National Highways Planning Response (NHPR 21-09) Formal Recommendation to an Application for Planning Permission

Council's Reference: 21/03268/OUT

Location: OS Parcel 2636, NW of Baynards House, Ardley

Proposal: Outline planning permission (all matters reserved except for access) for the erection of buildings comprising logistics (Use Class B8) and ancillary Office (Use Class E(g)(i)) floorspace; construction of new site access from the B4100; creation of internal roads and access routes; hard and soft landscaping including noise attenuation measures; and other associated infrastructure

Section 6-6 (1:250 @A1)

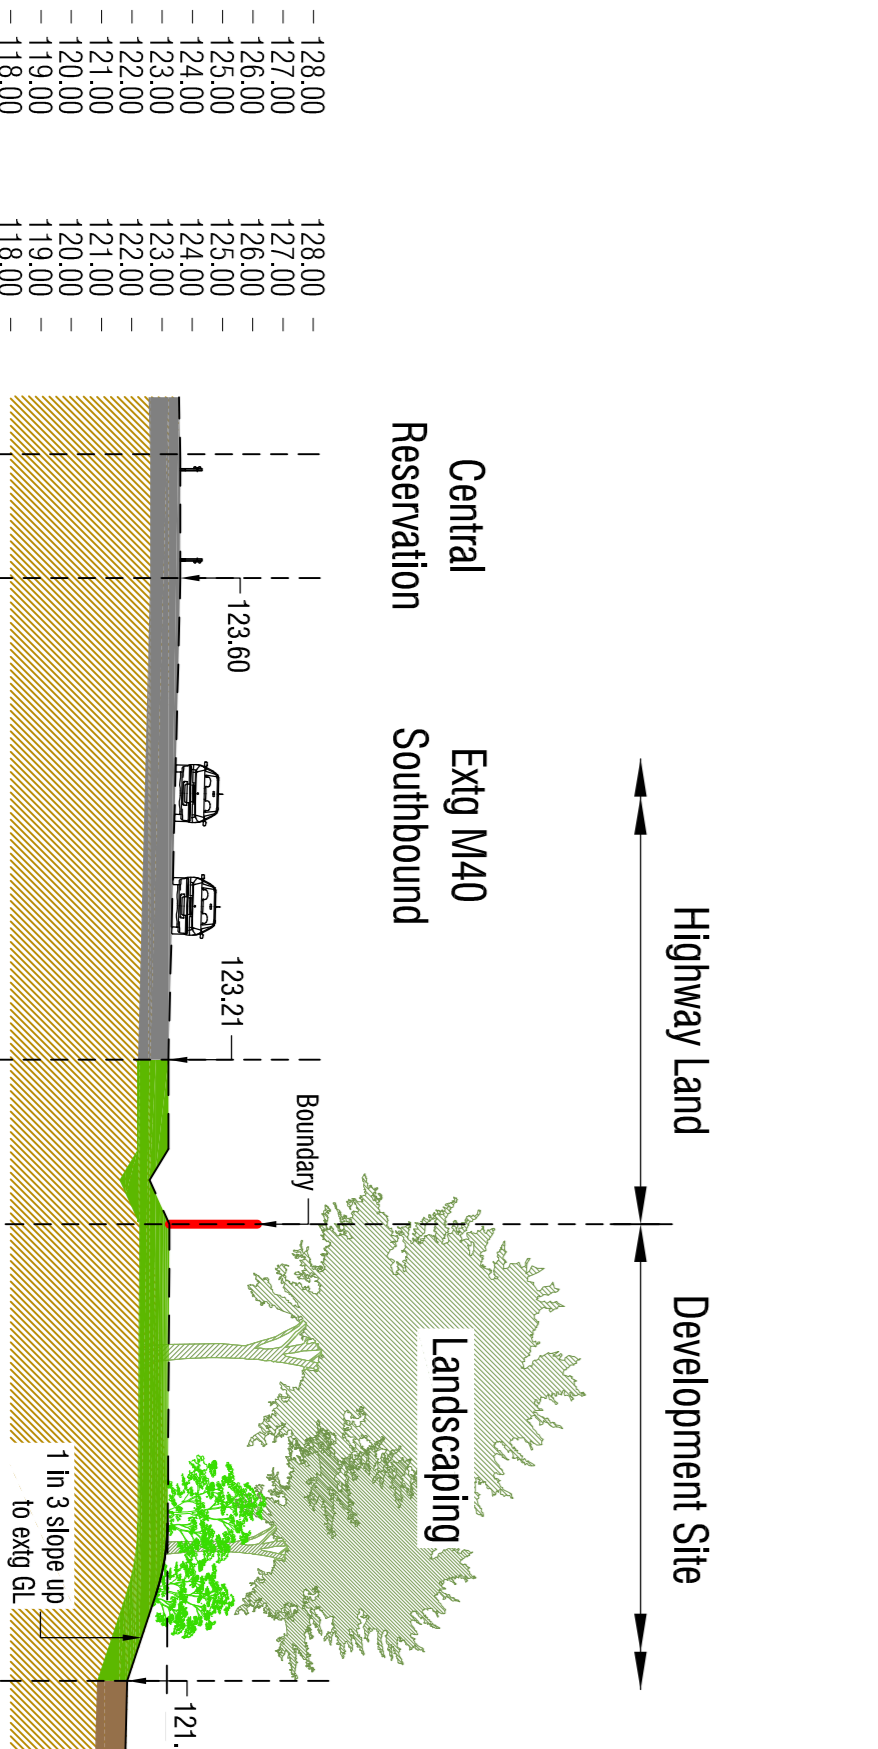
The applicant will need to advise / confirm if there will be any earthworks associated with the development(s) in relatively close proximity to National Highways boundaries (e.g. the stability of the balancing ponds, etc). In the first instance, some cross sections (to scale) through the boundaries showing the proposed extent of the development, its features and any proposed changes in elevation (excavations, landscaping) etc should be submitted for further assessment. Once received, we will review to determine the possible extent of any geotechnical reporting under the Design Manual for Roads and Bridges (DMRB) standard CD 622, which may be required to confirm the extent of any geotechnical risk to the SRN.
